# CITY OF ALBUQUERQUE

**Re: Mister Carwash**  
**4709 ALAMEDA BLVD NE**  
**Traffic Circulation Layout-DFT Approval**  
Engineer's/Architect's Stamp 06-21-24 (C17D002A26C)

Based upon the information provided in your submittal received 07-02-24, the above referenced plan cannot be approved for Building Permit until the following comments are addressed:

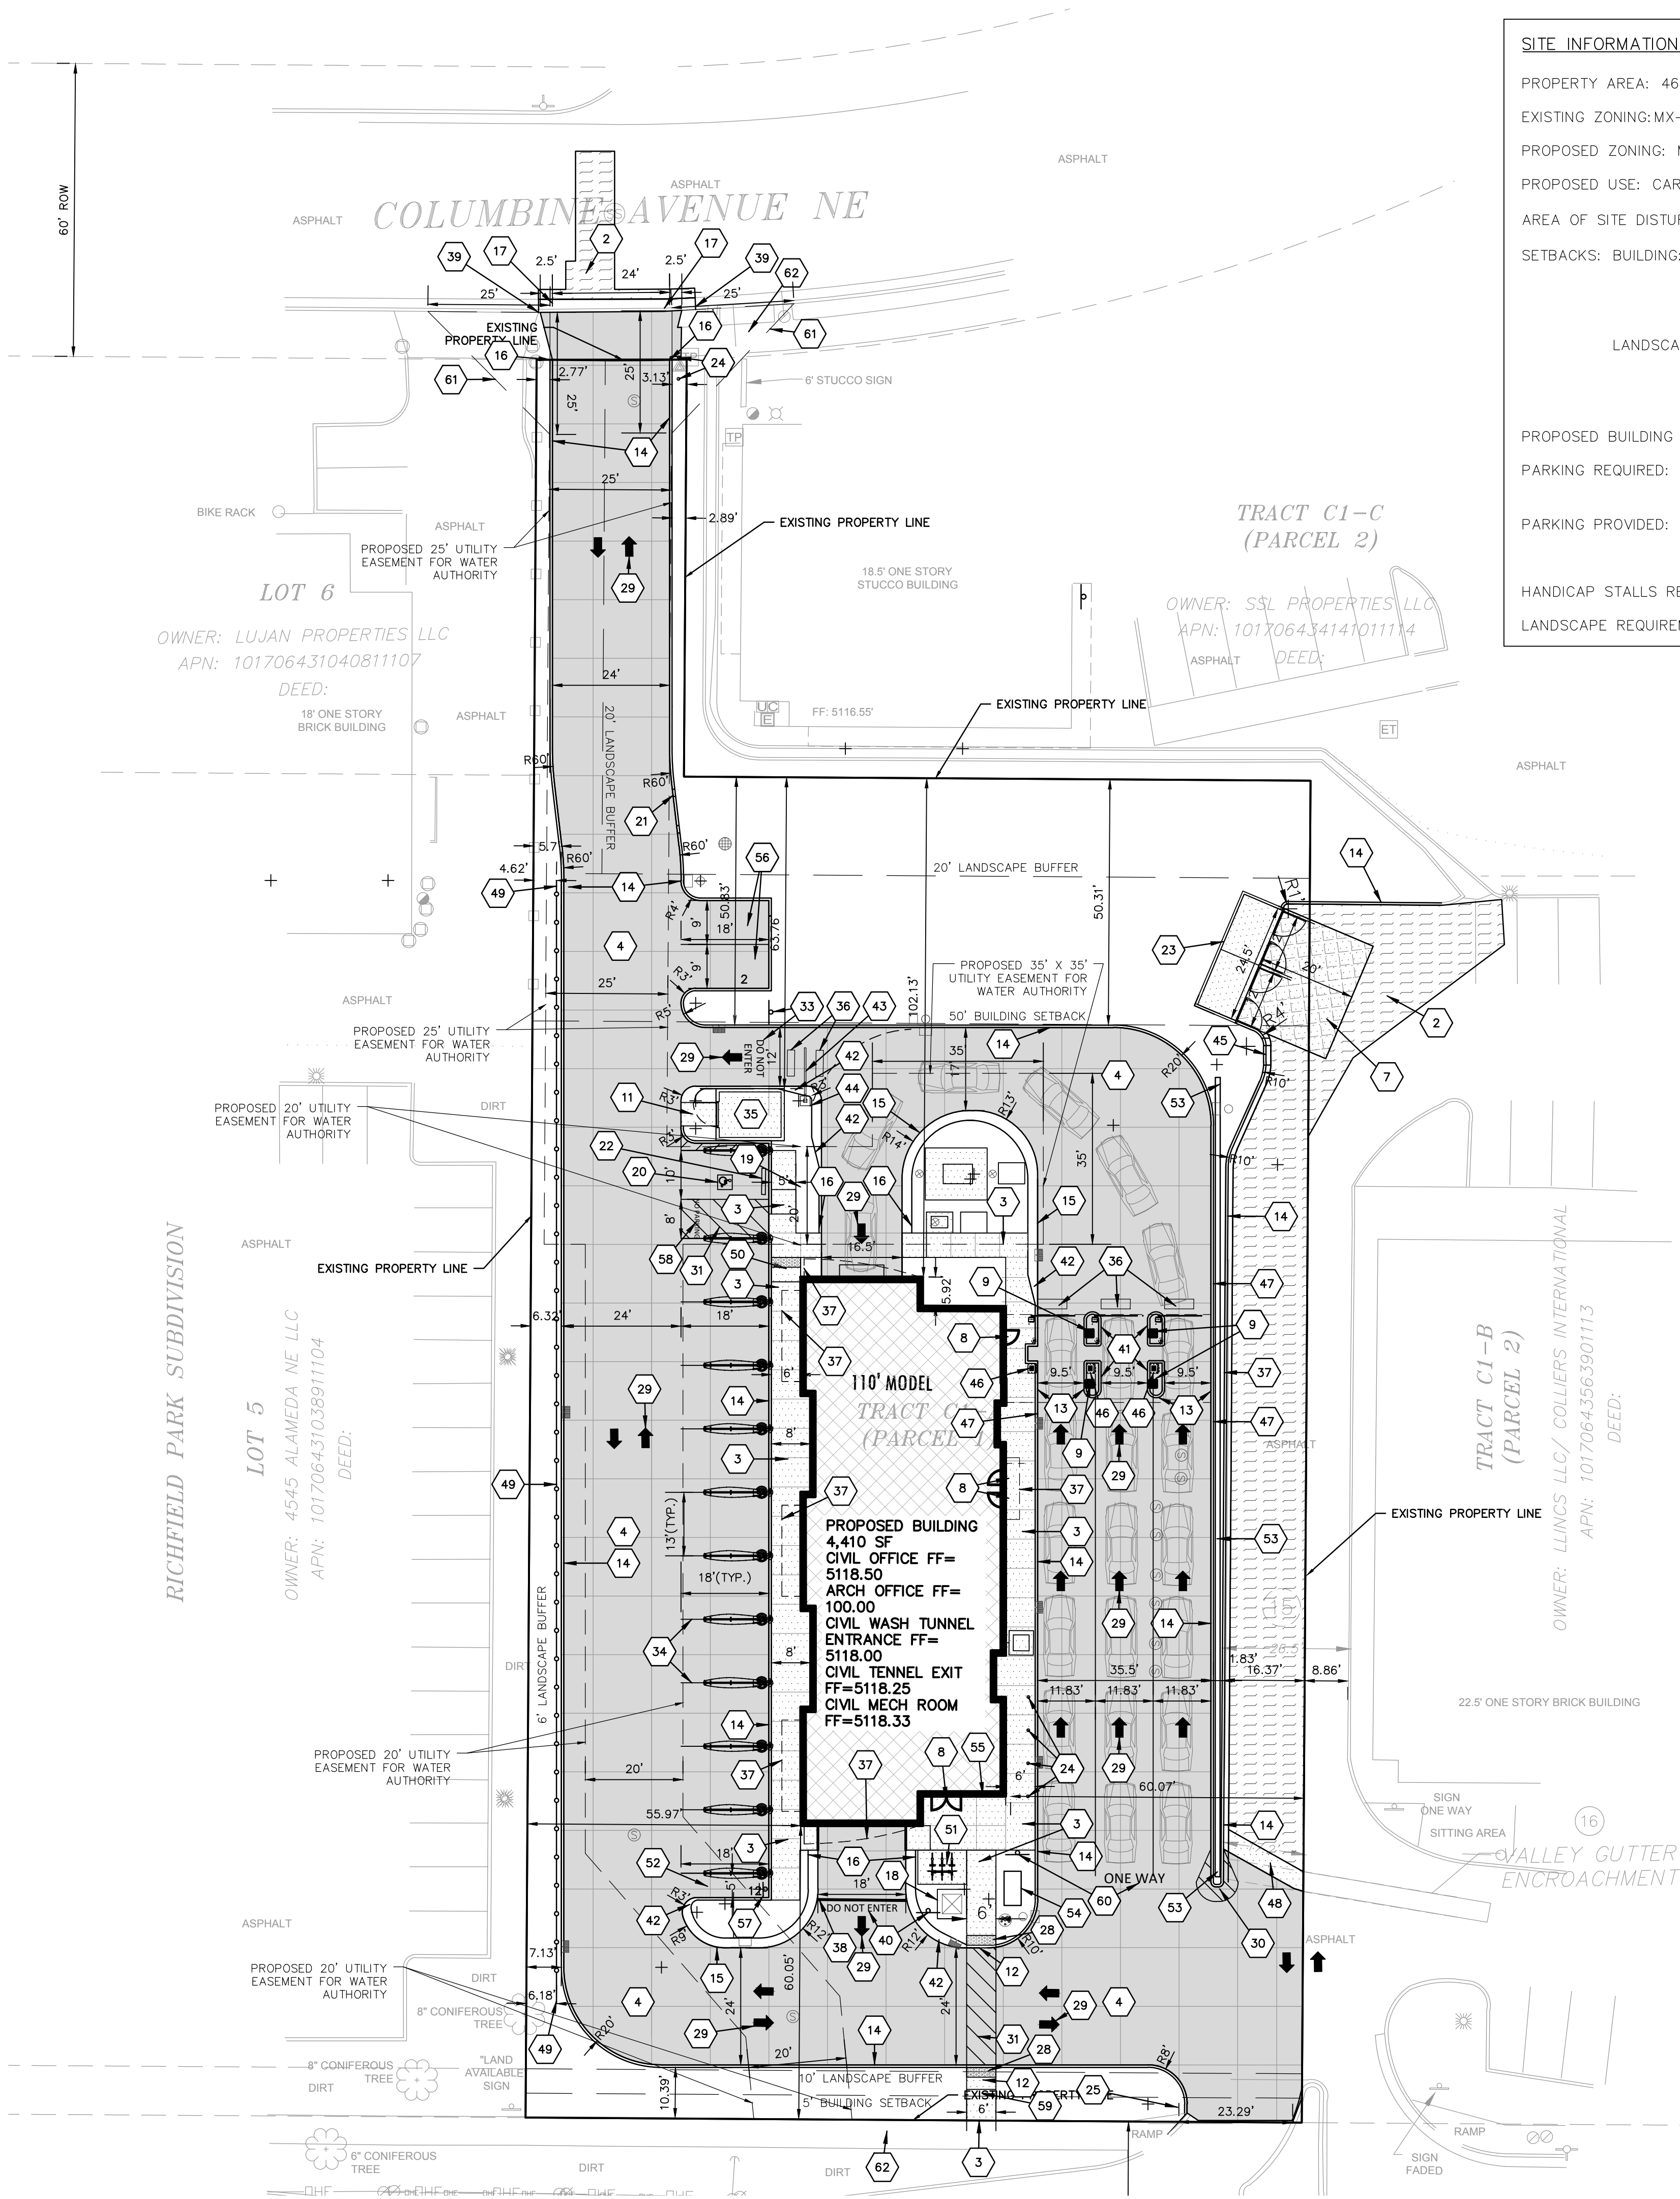
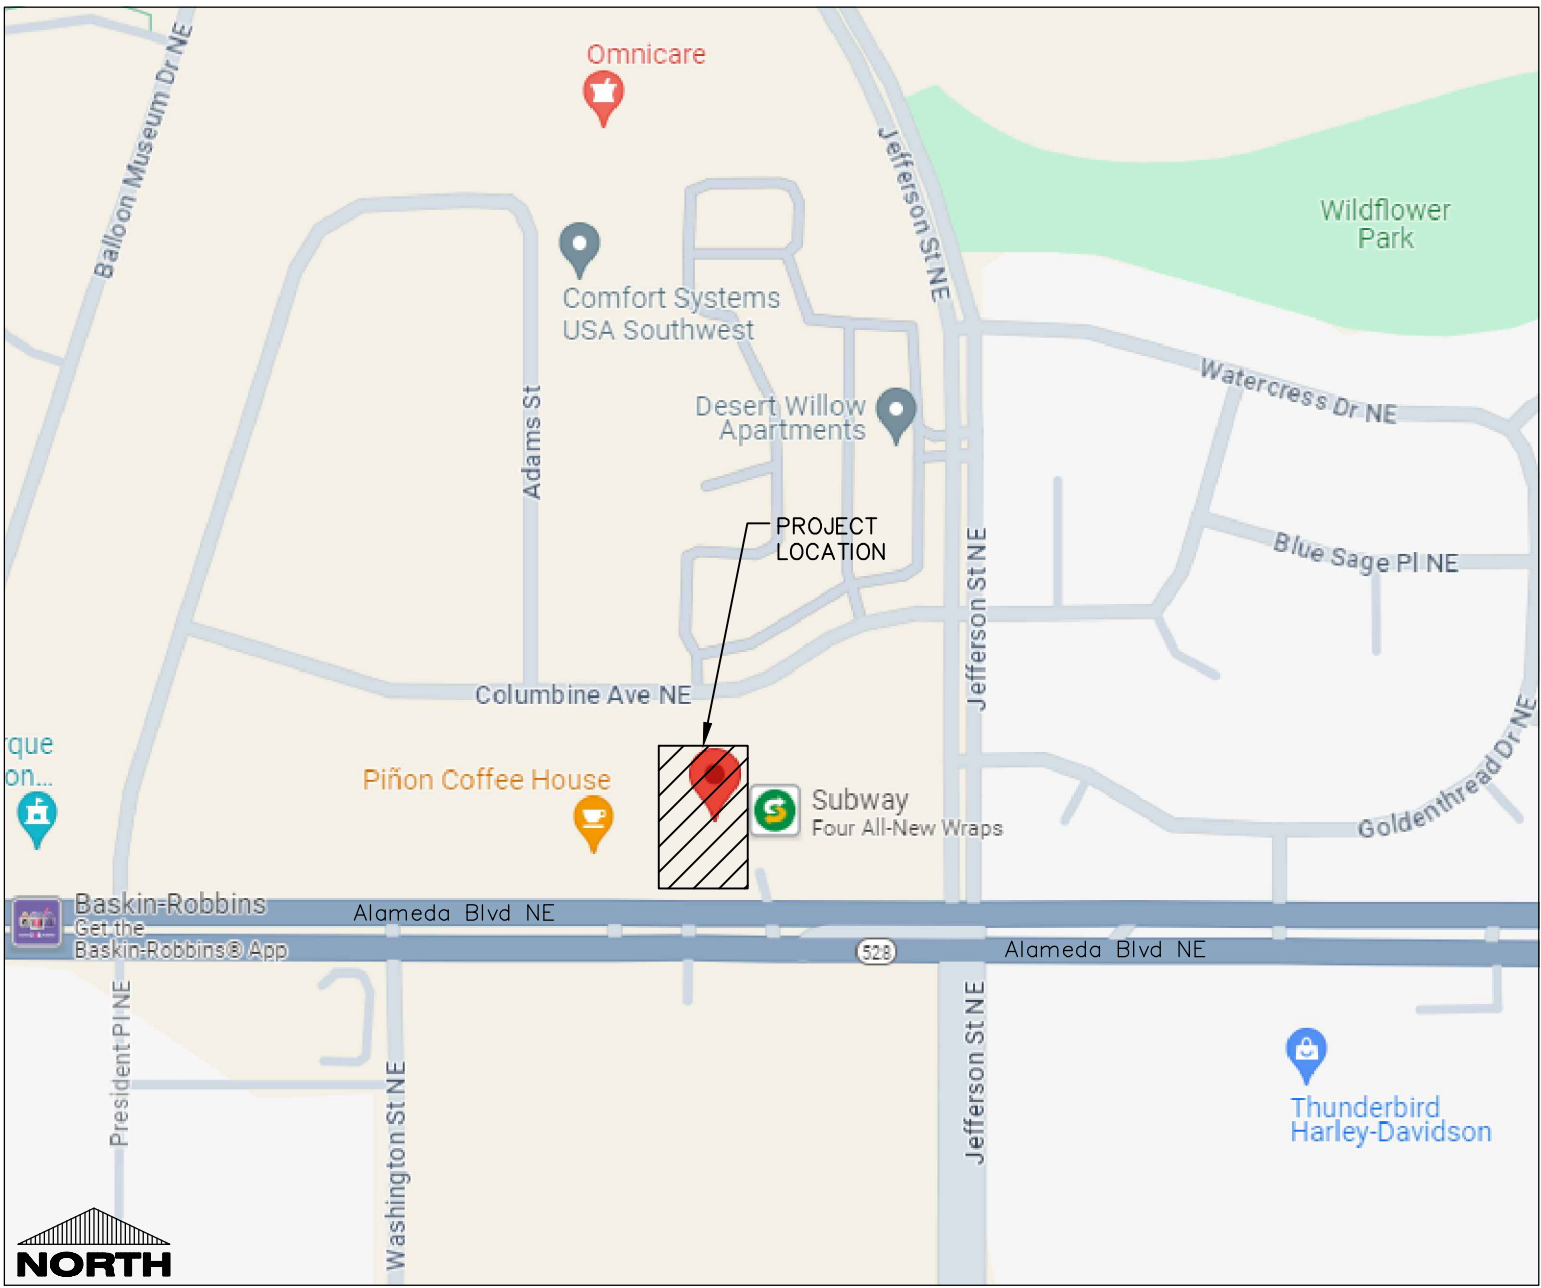
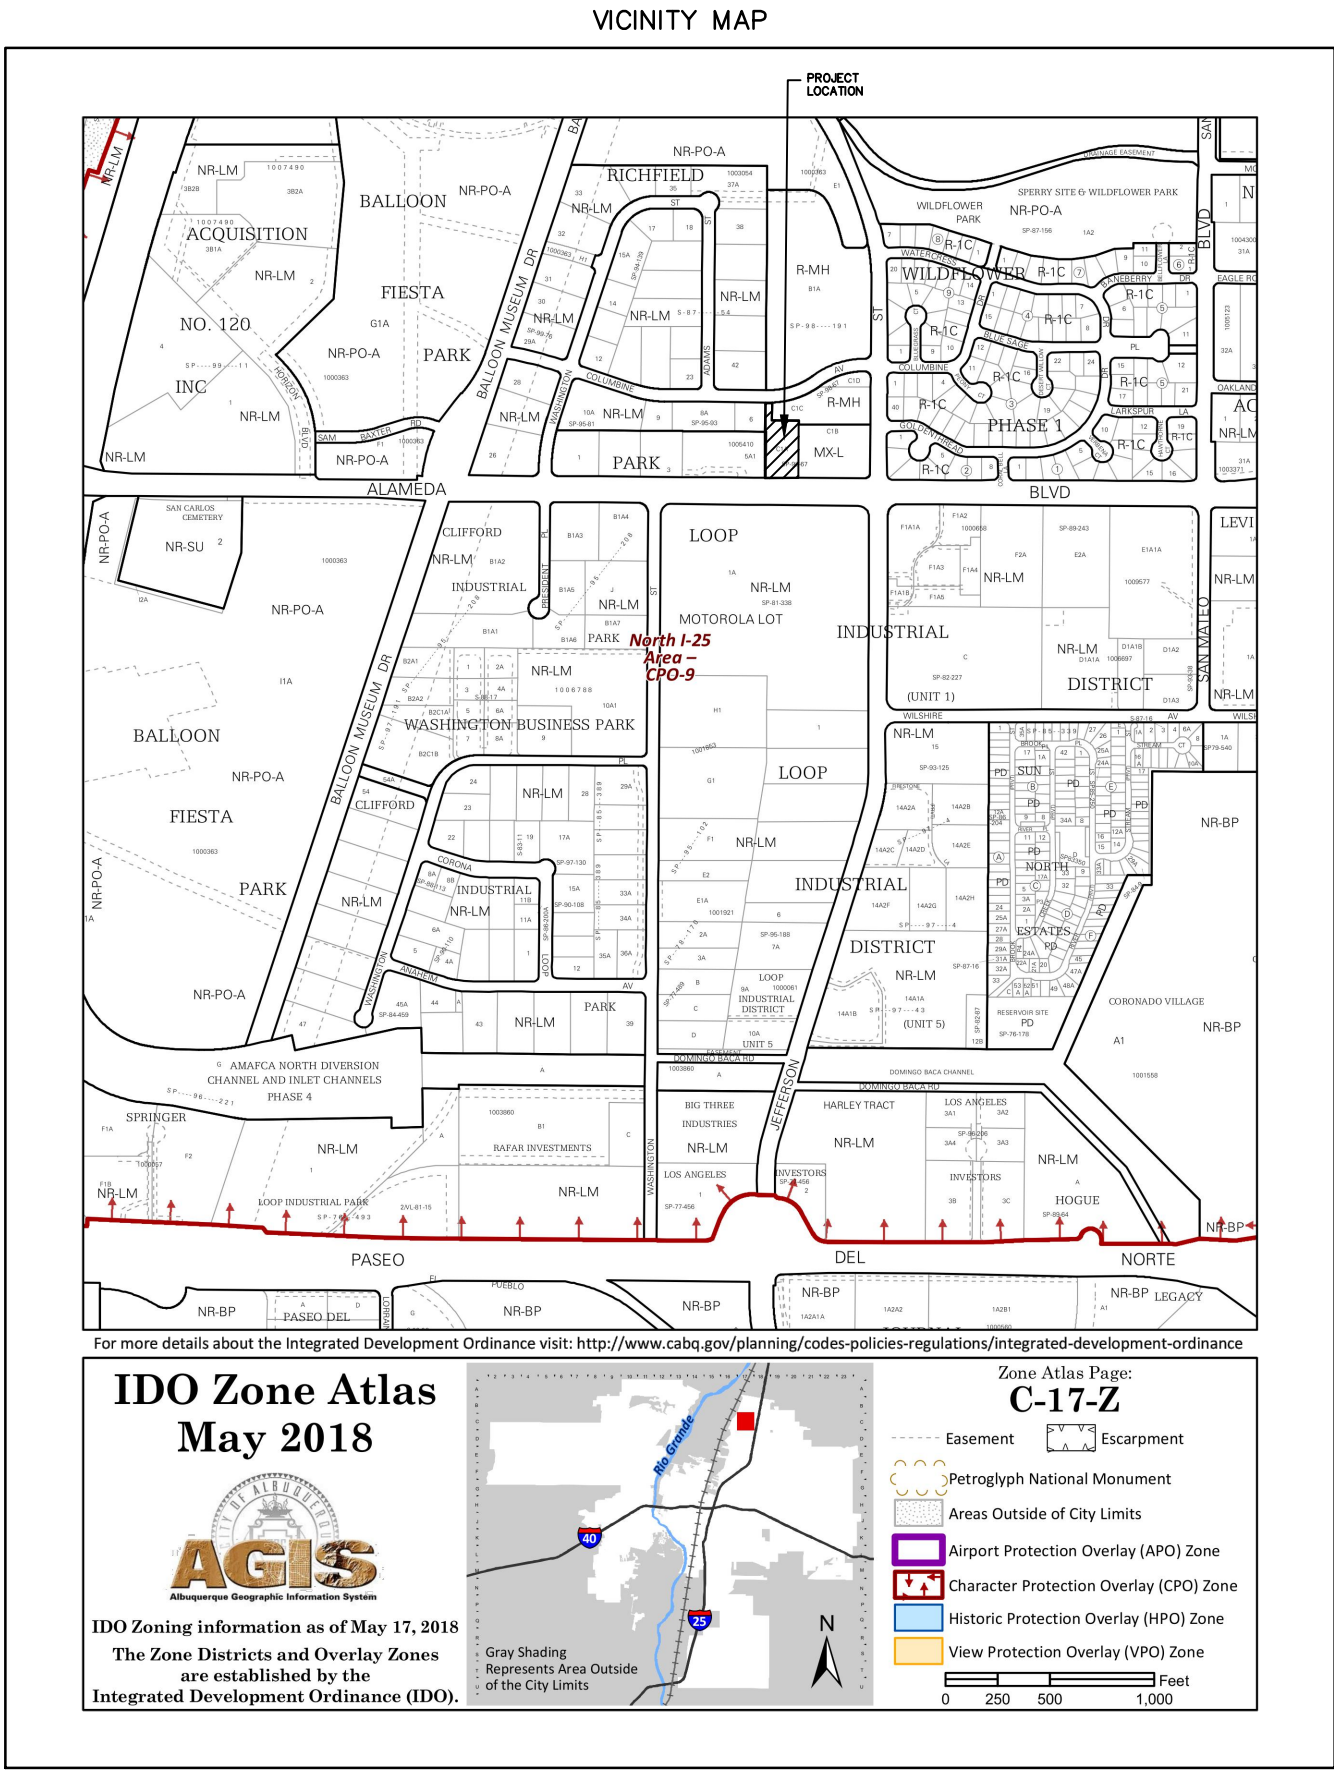
1. Please show a vicinity map showing the location of the development in relation to streets and well known landmarks.
2. Show the location of parking spaces for the employees. Also motorcycle parking signage is required.
3. Some of the sheets are not stamped, signed, and dated by an engineer or architect licensed in the state of New Mexico.
4. Clarify existing property lines and proposed property lines.
5. All accessways to the site from the adjacent roadway shall be ADA-compliant.
6. Please list the width and length for all proposed parking spaces. Some dimensions are not shown.
7. The minimum parking stall dimensions are:

8. The ADA accessible spaces must include an access aisle. Van accessible aisles should be 8ft wide; all others should be 5ft wide.
9. The ADA access aisles shall have the words "**NO PARKING**" in capital letters, each of which shall be at least one foot high and at least two inches wide, placed at the rear of the parking space so as to be close to where an adjacent vehicle's rear tire would be placed. (66-1-4.1.B NMSA 1978)

10. ADA curb ramps must be updated to current standards and have truncated domes installed.
11. 9' radii is not enough. Make it 20'.

12. Is this a typo mistake?

13. Per the DPM, a 6 ft. wide ADA accessible pedestrian pathway is required from the public sidewalk to the building entrances. Please clearly show this pathway and provide details.
14. All one-way drives shall have "One Way" and "Do Not Enter" signage and pavement markings. Please show detail and location of posted signs and striping.
15. The minimum drive through lane width is 12 feet with a 25 foot minimum radius (inside edge) for all turns. (A 15 foot radius can be used with an increase in lane width to 14 feet). 9.5' is very narrow.

16. Please provide a sight distance exhibit
17. Show the clear sight triangle and add the following note to the plan: "Landscaping and signage will not interfere with clear sight requirements. Therefore, signs, walls, trees, and shrubbery between 3 and 8 feet tall (as measured from the gutter pan) will not be acceptable in the clear sight triangle."

18. Please specify the City Standard Drawing Number when applicable.
19. Shared Site Access: driveways that straddle property lines, or are entirely on one property but are to be used by another property, shall have an access easement. Please include a copy of your shared access agreement with the adjacent property owner.
20. Add a note stating "All broken or cracked sidewalk must be replaced with sidewalk and curb & gutter." A build note must be provided referring to the appropriate City Standard drawing.
21. There is variation in plan at the highlighted location below:

22. Show location of overhead utility lines in relationship to the buildings.
23. Please provide the readable copy of this sheet:
